From: Graham Ross [graham@gardenclinic.com.au]
Sent: Monday, 5 November 2012 1:32 PM
To: plan_commenty@planning.nsw.gov.au
Cc: Steve.Warnock@minister.nsw.gov.au; ulienne86839@hotmail.com; gail@pergolatrends.com.au; Linda Ross; Kent Ross; Sandra Ross
Subject: Northern Sydney Freight Programme

Director- Infrastructure Projects
Epping to Thornleigh Third Track Project – SSI 5132
NSW Department of Planning & Infrastructure
Sydney NSW 2001

Re: Epping to Thornleigh Third Track Project – SSI 5132

Figure 5.5 Artist's impression of new elevated concourse at Cheltenham Station looking south from The Crescent (indicated circle)

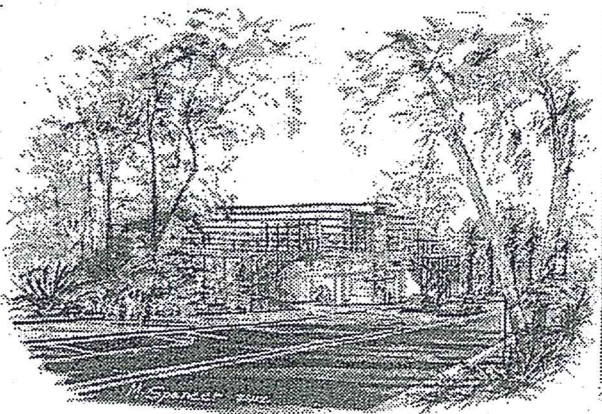
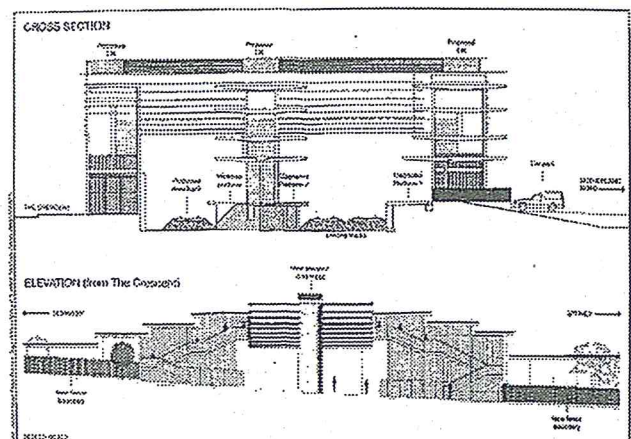
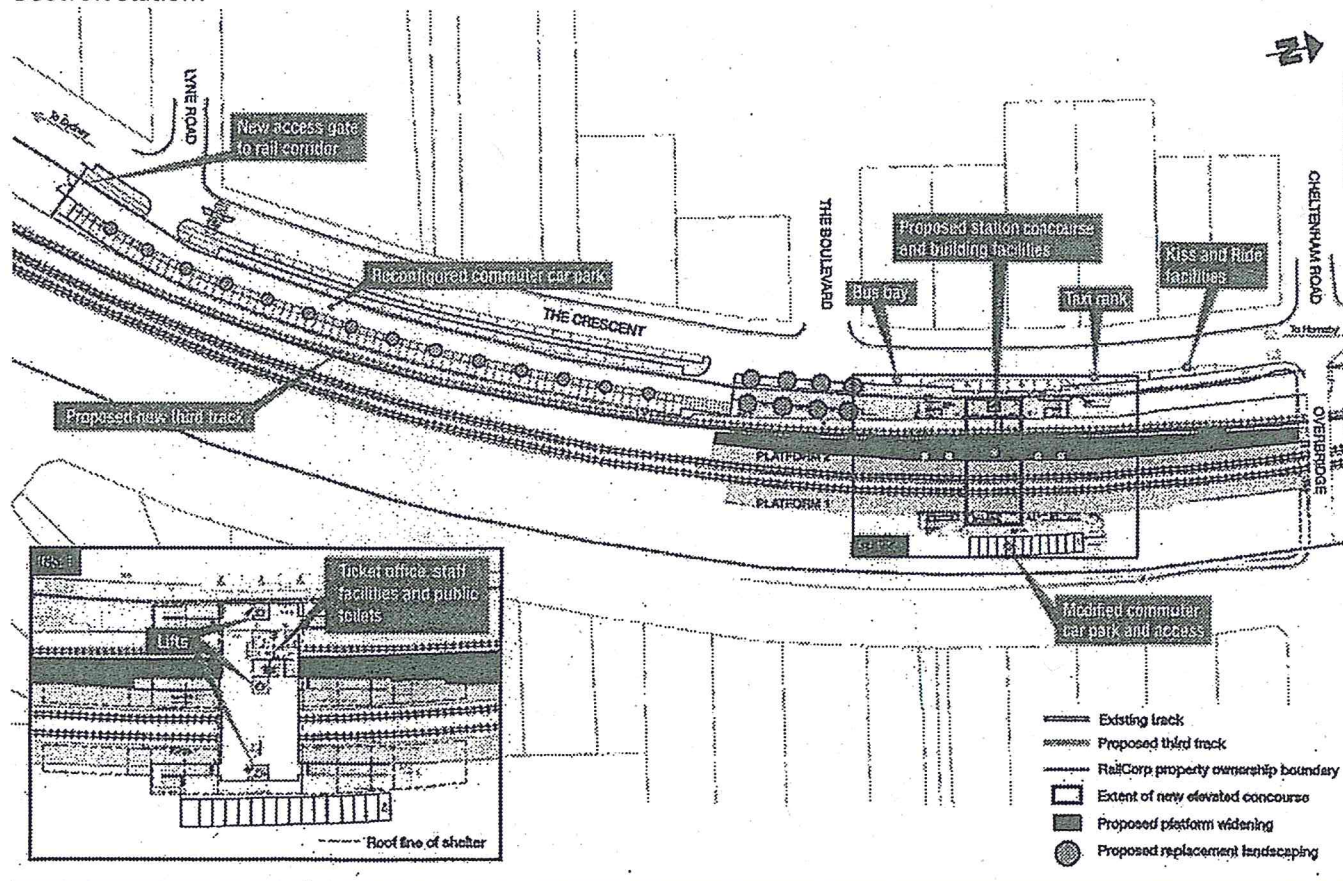
When the Mt Pleasant Estate was built the community, NOT the state government, paid for the railway station which has wonderful heritage values. The EIS adopts the totally unacceptable position that a nice new metal and glass number would be appreciated by the community. NO WAY. The station needs to be retained as is and not tampered with.
